**Consultation Response from KC,
Lead Local Flood Authority**

2025/93543 land at, former Clough Mill, Clough Road, Slaithwaite, Huddersfield, HD7 5DB

Erection of 33 dwellings (c3) with access from Clough Road and associated works including engineering operations, construction of retaining walls and landscaping

**Date Responded: 31st March 2026
Responding Officer: Paul Farndale
Responding Ref: 1**

Proposed Layout
Design Review

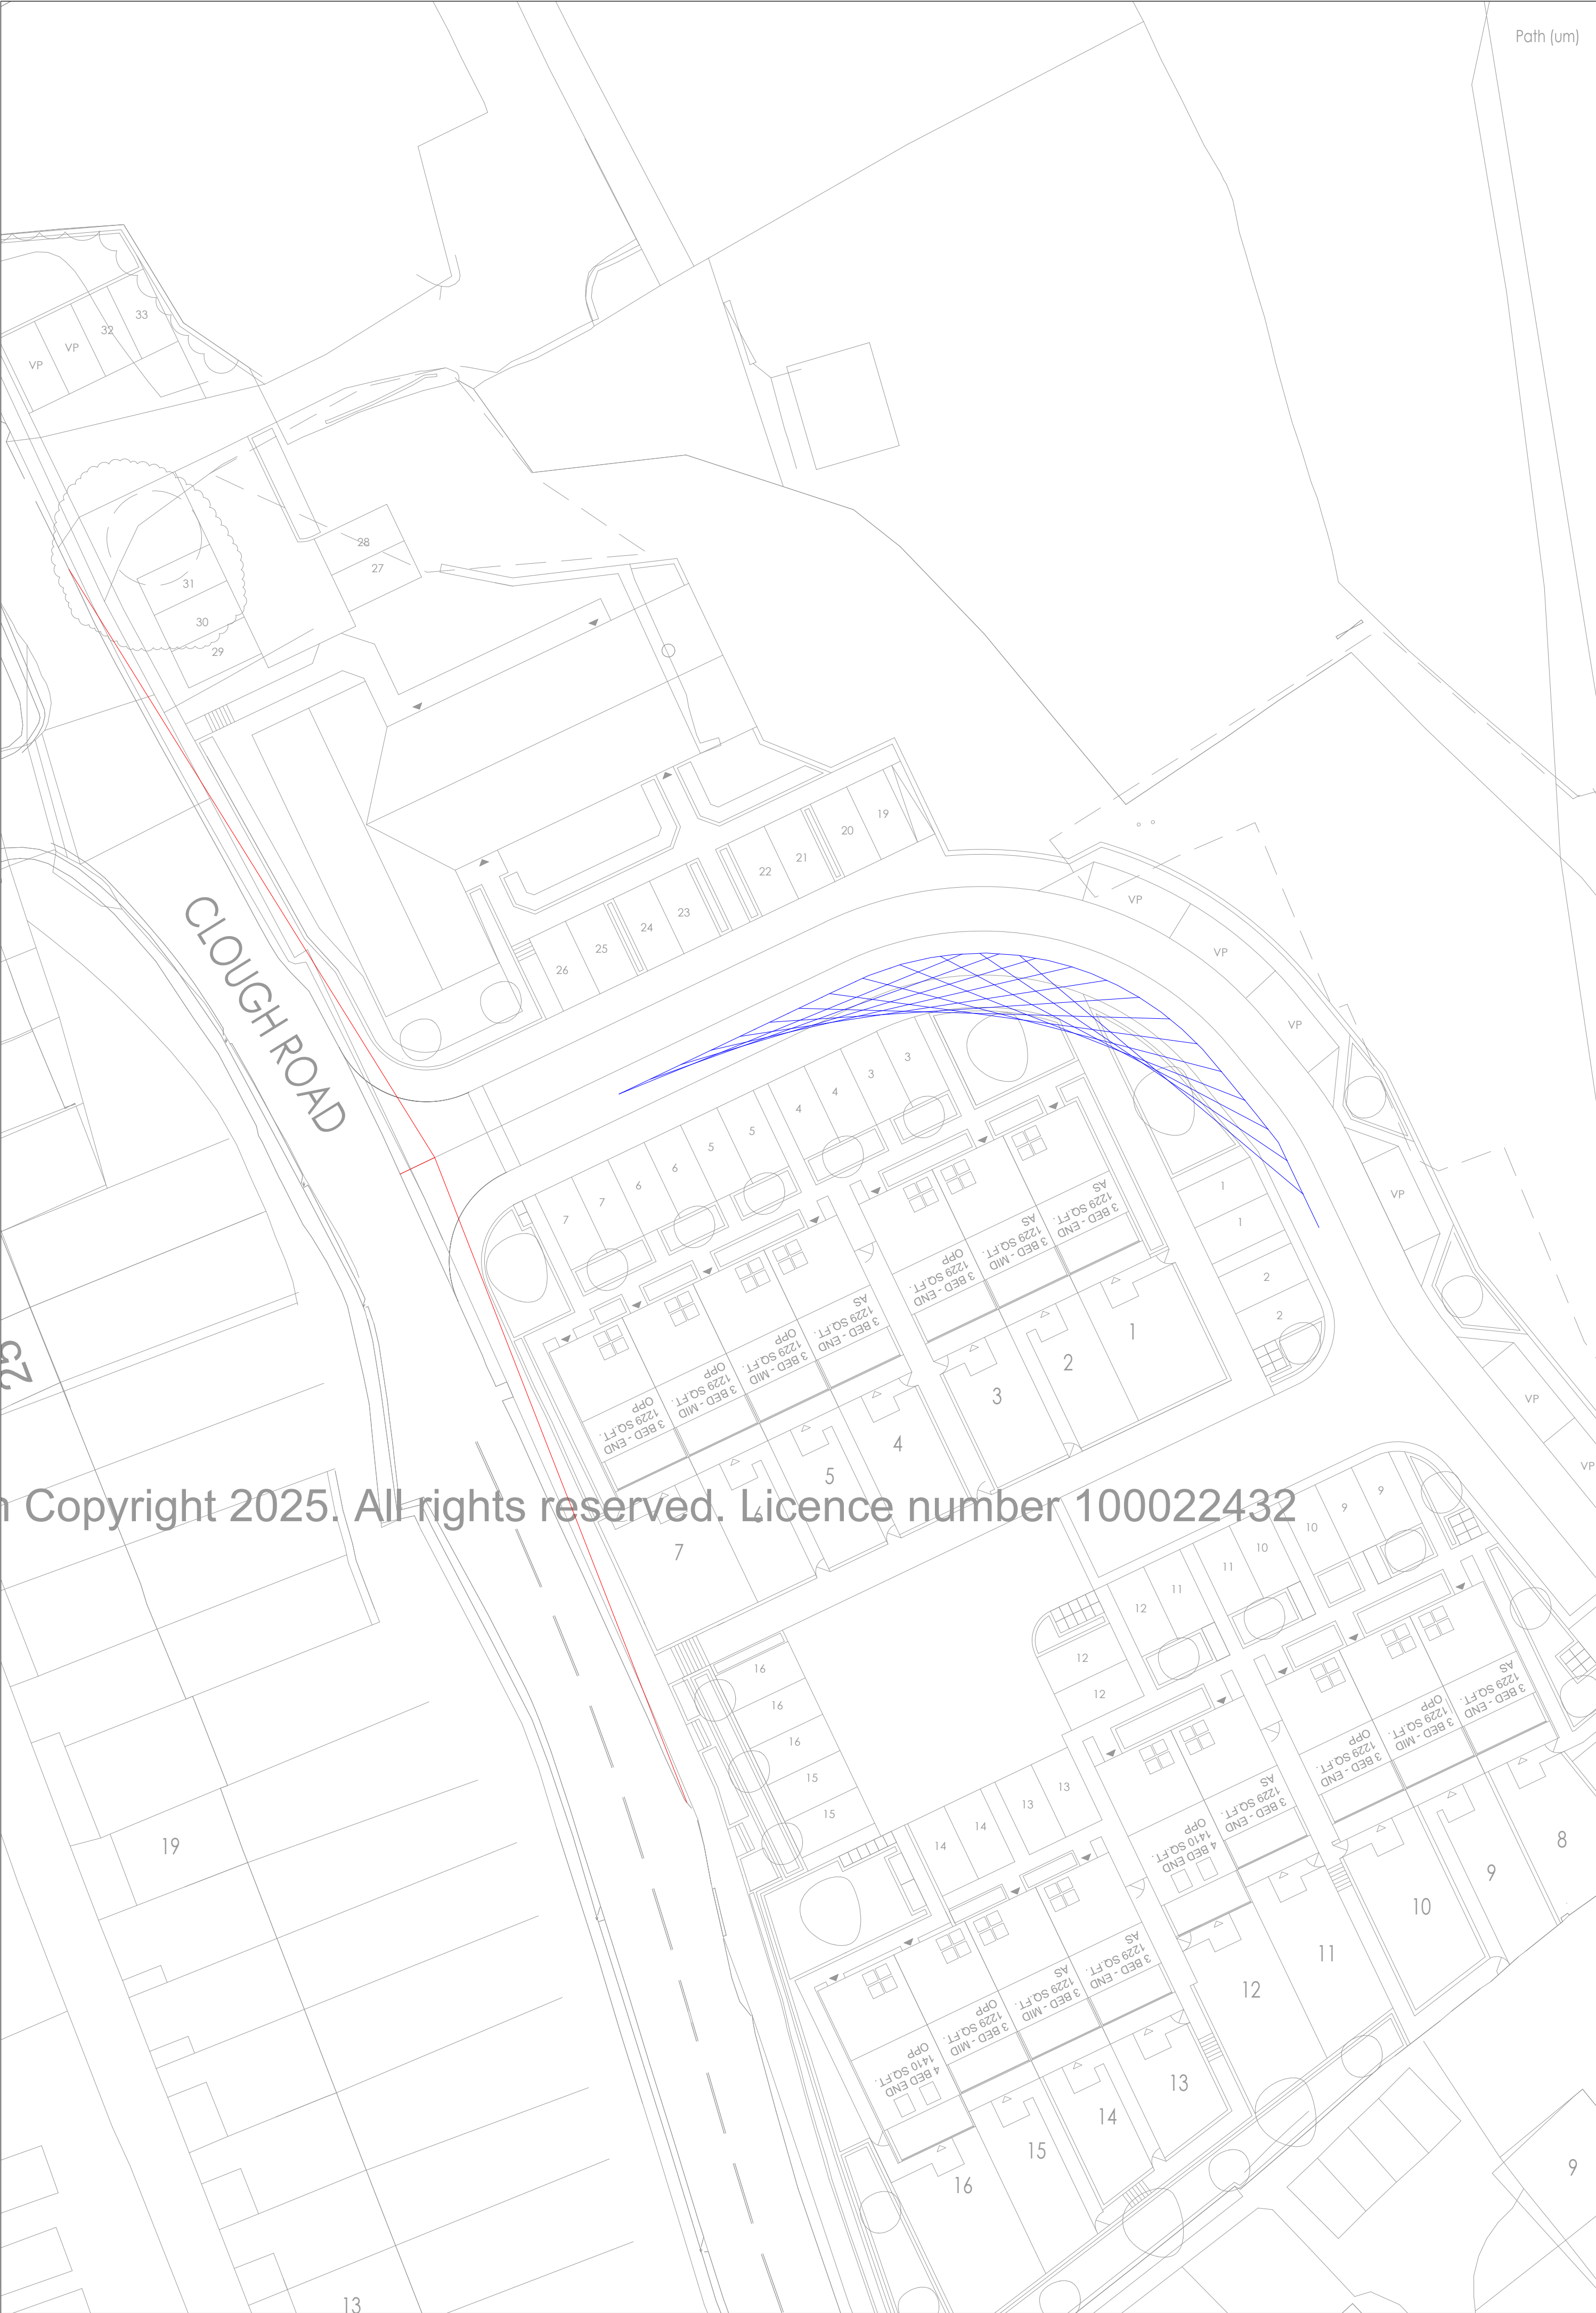
The FRA notes that flows onto and within the site caused ponding and waterlogged near the existing retaining wall. Also, that water worked its way into redundant pipework which was broken causing flooding at Crowther Close. **Land Drainage/Interceptor drainage is required for the perimeter of the back of the site. This will need to be managed by a management company. A provisional scheme is required to be shown on a plan.**
